PLANNING AMENDMENT

Application No: H12-0631-11/A1

Description: Replacement of storage building with showroom and 2 holiday flats

**RE: PROPOSED SHOWROOM EXTENSION AND HOLIDAY FLATS AT RED
MAYS FARM, LIME WALK, LONG SUTTON FOR HALLGATE TIMBER LTD**

1:50 1:100 SD11-019/4

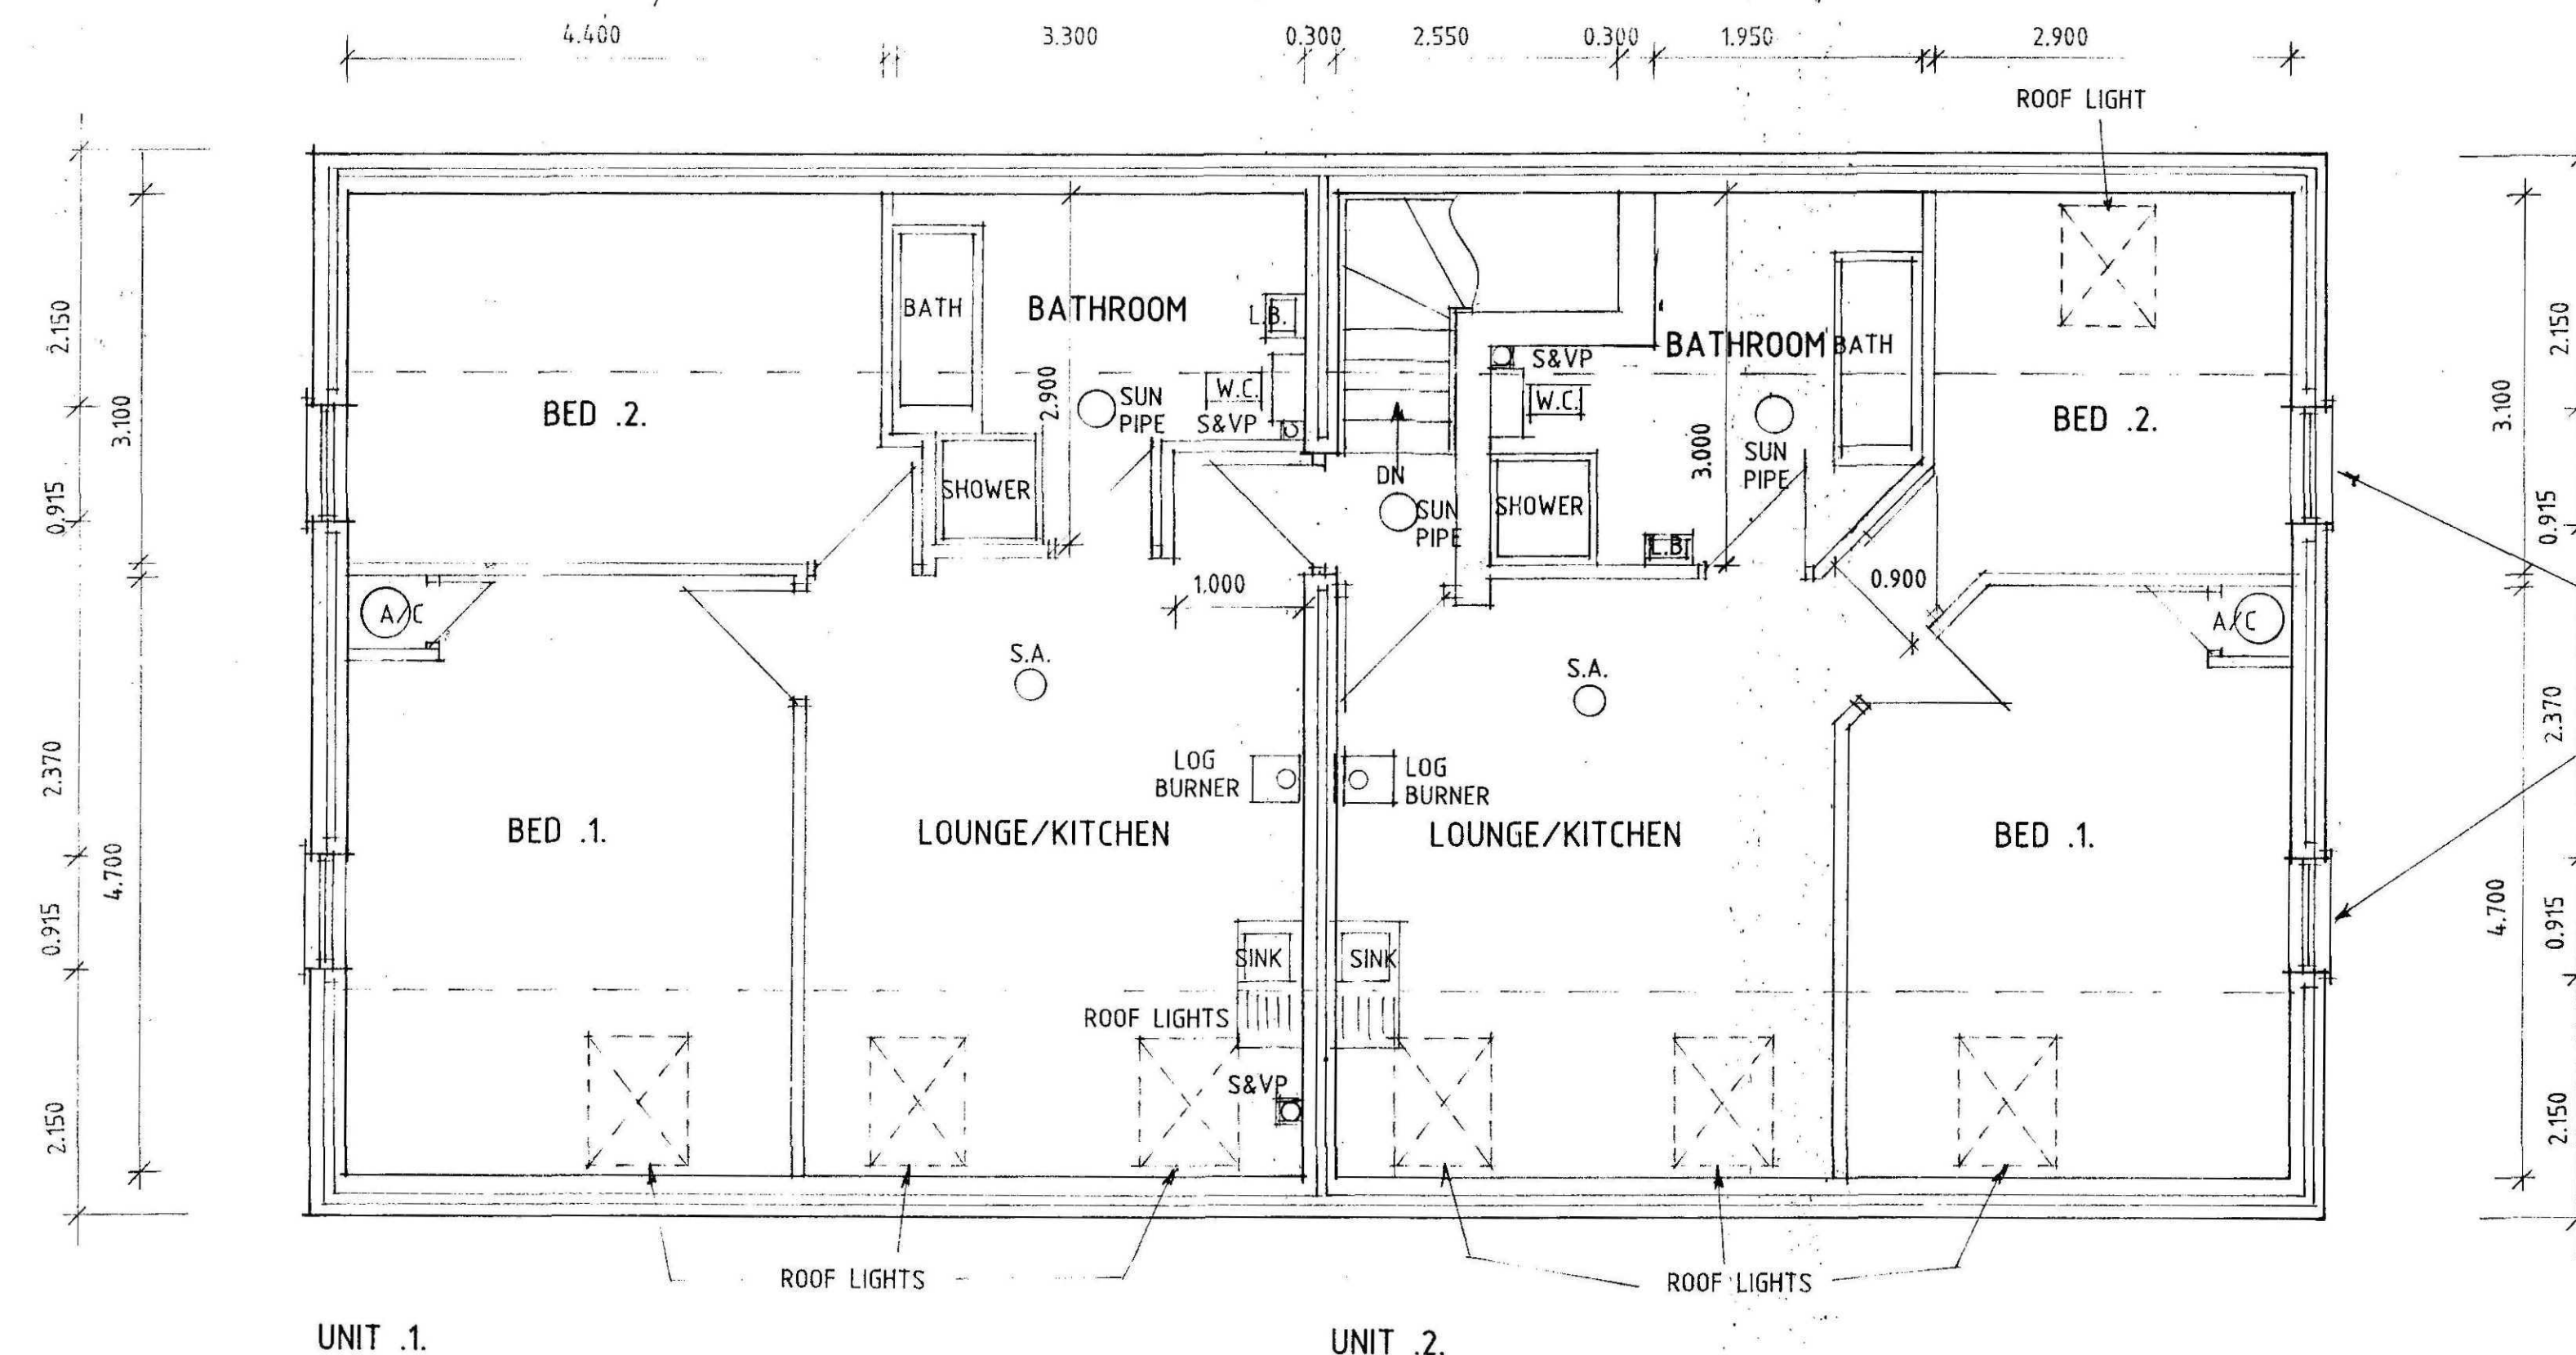
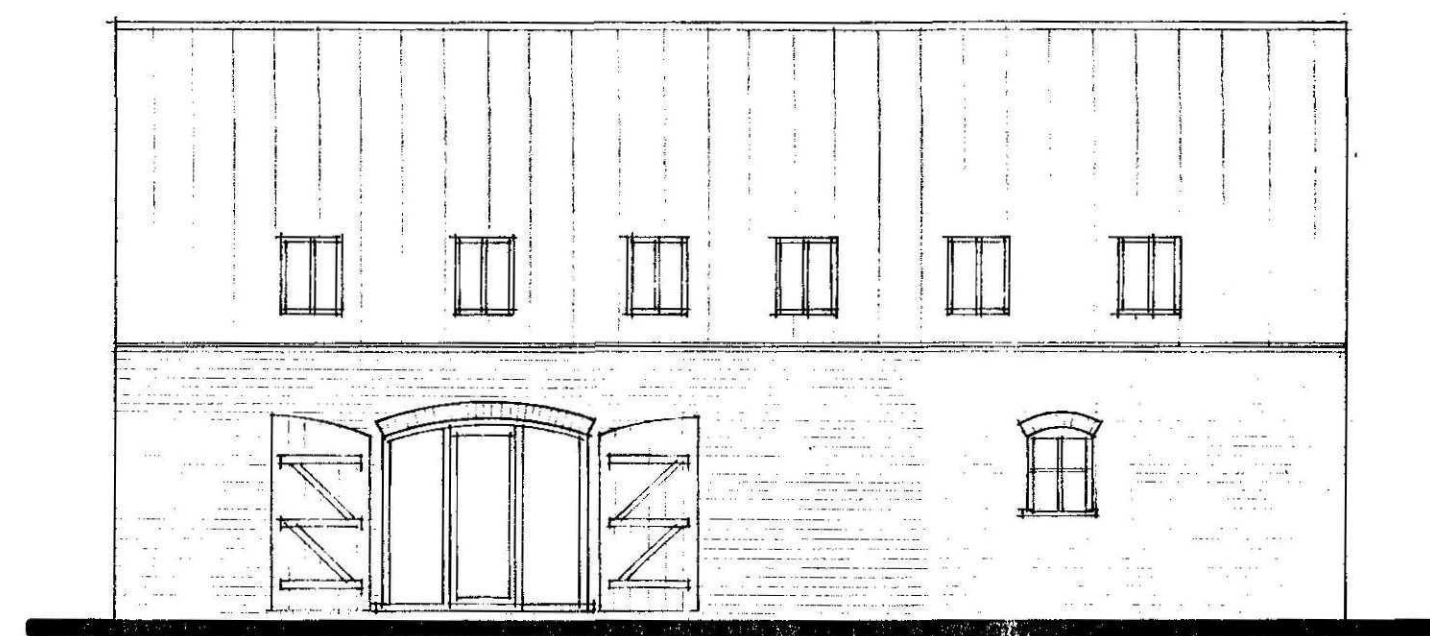
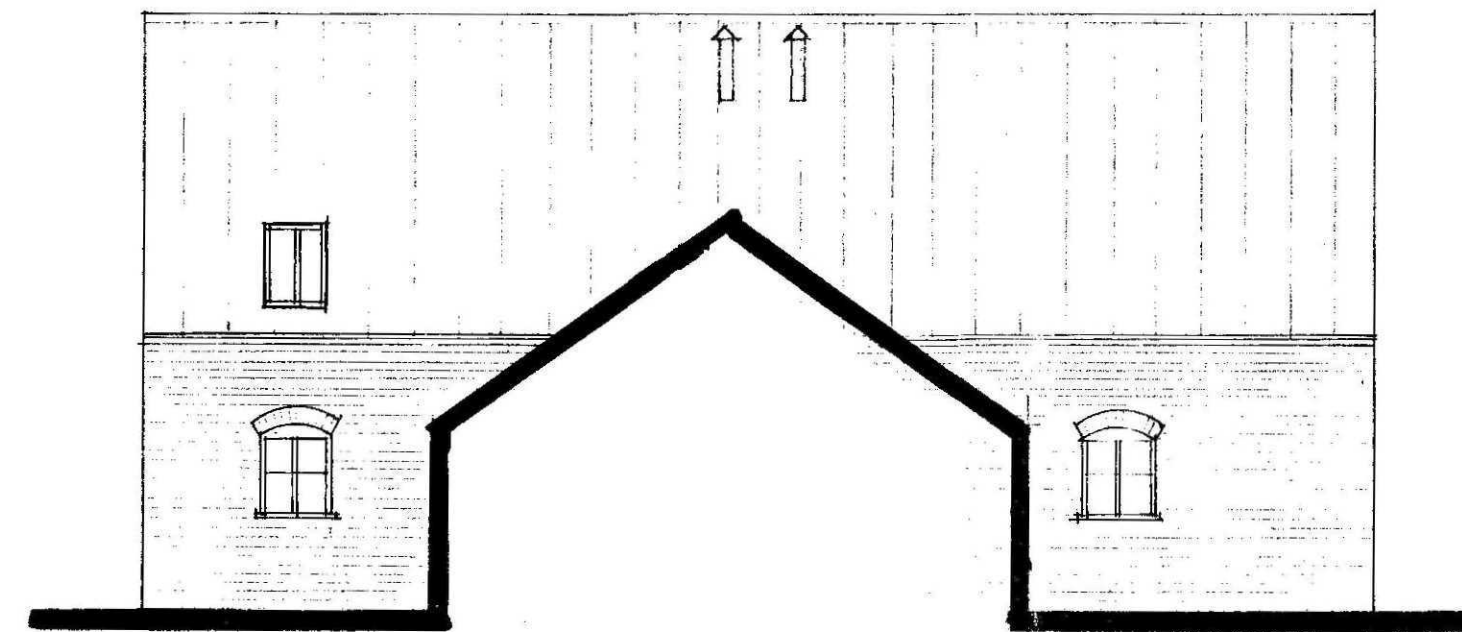
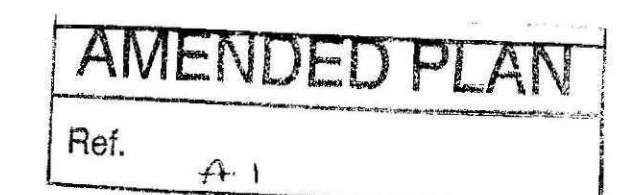
Amendment: Add roof light, plus bottom half of side window of bedrooms
1 & 2 of Unit 2 obscured glazed and top half opening

Further to our recent telephone conversations in respect of your concern regarding the overlooking of the neighbouring bungalow from Bedrooms 1 and 2 of Unit 2, I enclose 2 no. copies of revised drawing no. SD11-019/4D showing bottom half of side windows to these bedrooms having obscured glass and only the top half opening.

To overcome the loss of "escape windows" to bedroom 2 a roof light has been added to the rear elevation.
